Preferred Project Report (PPR)

Former Rachel Forster Hospital MP 09-0068
134-144 Pitt Street, Redfern

Major project for the redevelopment of the former Rachel Forster Hospital site for residential (158 units) and public open space purposes with basement parking (170 car spaces)

June 2013

1 NORTH ELEVATION BUILDING 3 (ALBERT STREET VIEW)
SCALE 1:200

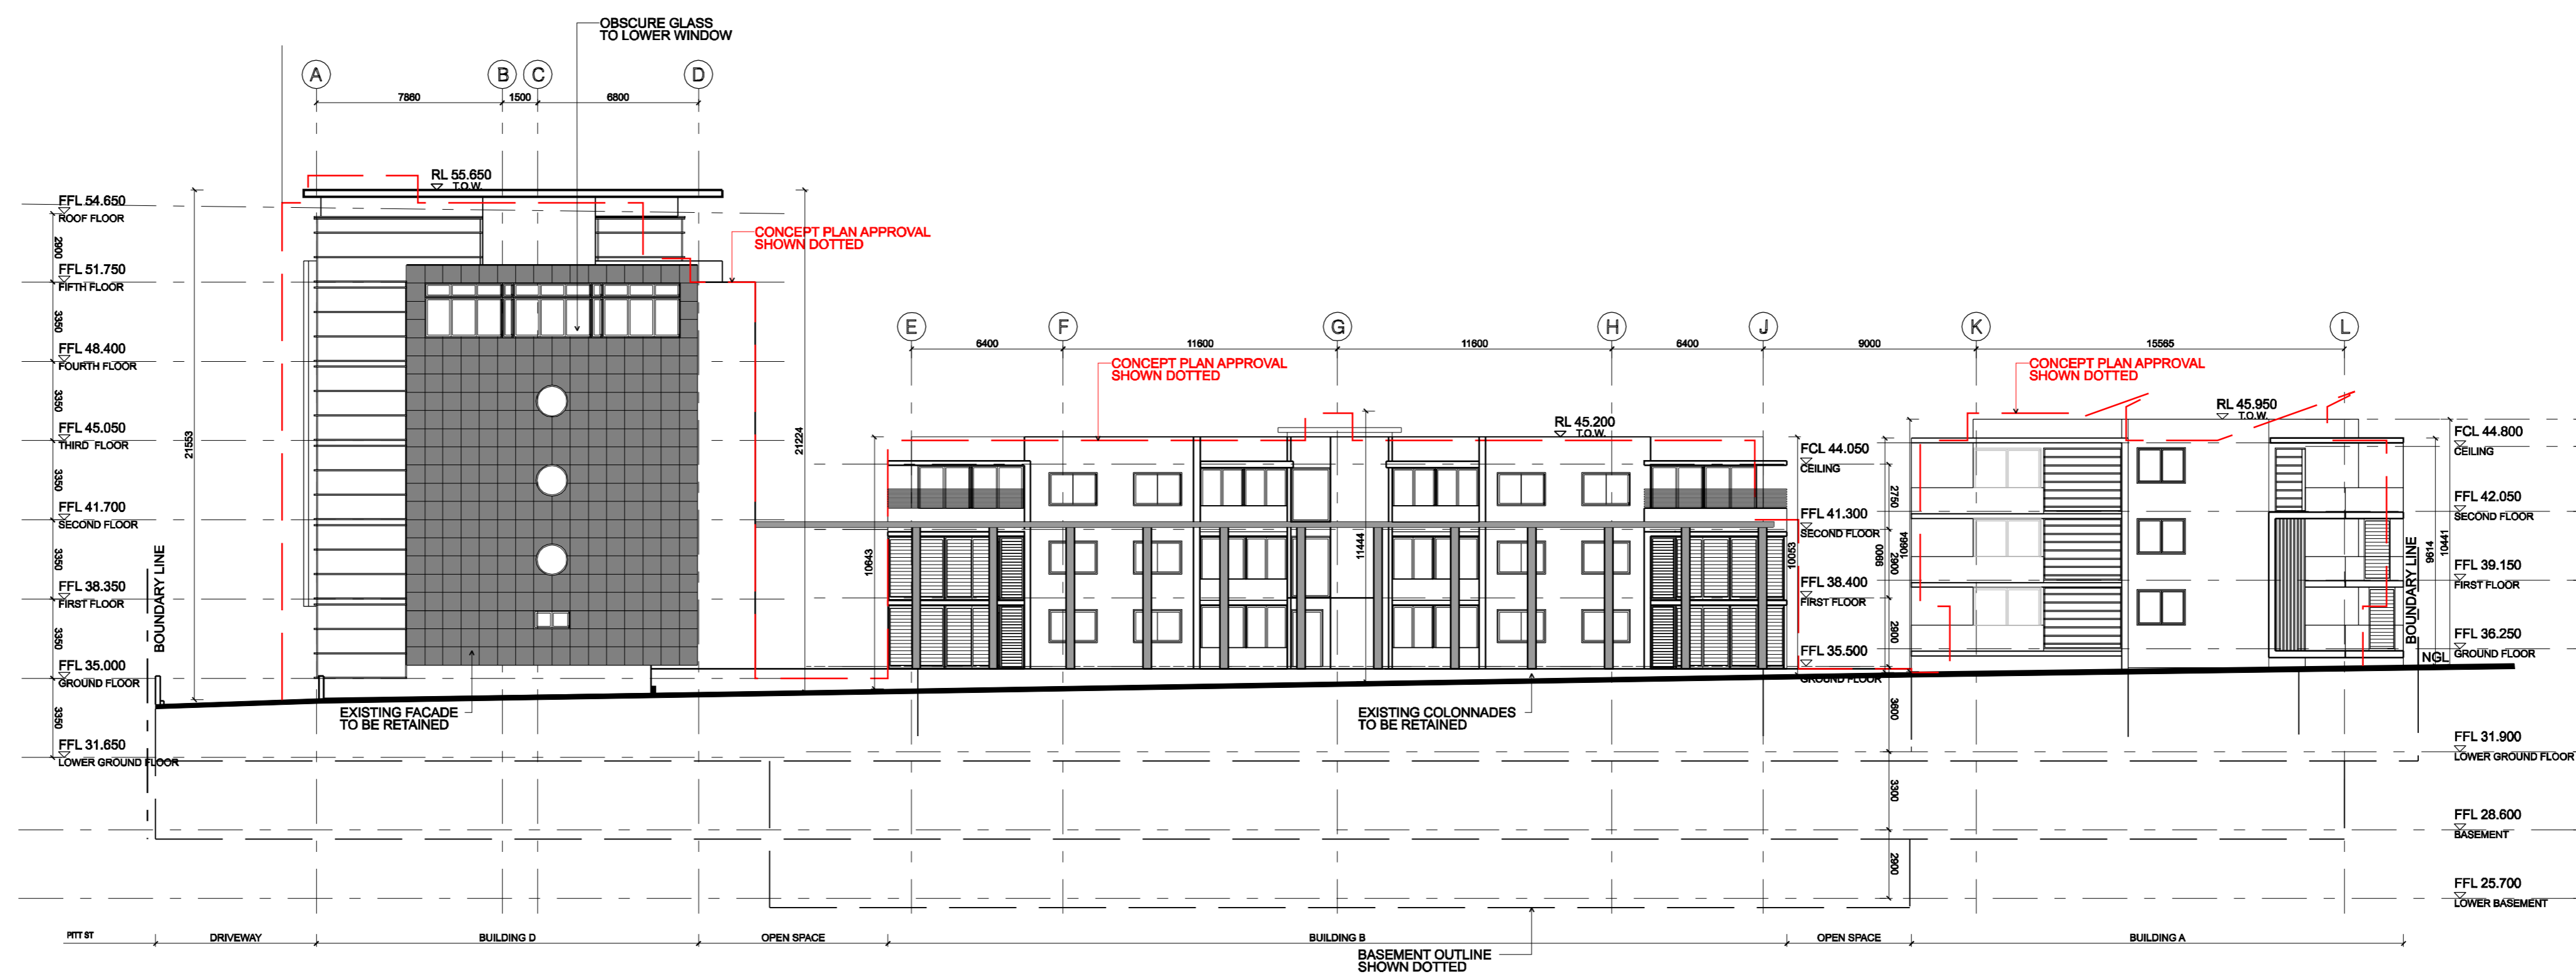
- *Details of treatment of the Albert Avenue interface of the lower ground level apartments is required in order to show how the issues of security, amenity and privacy are addressed for these units. The proposed access to the ground level apartments and lobbies should also be considered in the exercise.*

Response: The lower ground units along the Albert Avenue interface have been treated in order to mitigate any privacy, security or amenity impacts through the provision of a secured door entrance and front fencing (boundary fence 1500mm in height) enclosing the terraces areas of the lower ground units. The high fencing and doors are considered to provide adequate privacy and amenity treatments for the subject units as well as the neighbouring properties across Albert Street as it prevents any overlooking and amenity impacts. Please refer to Architectural Plans - North Elevation Plan A020 Elevations 01.
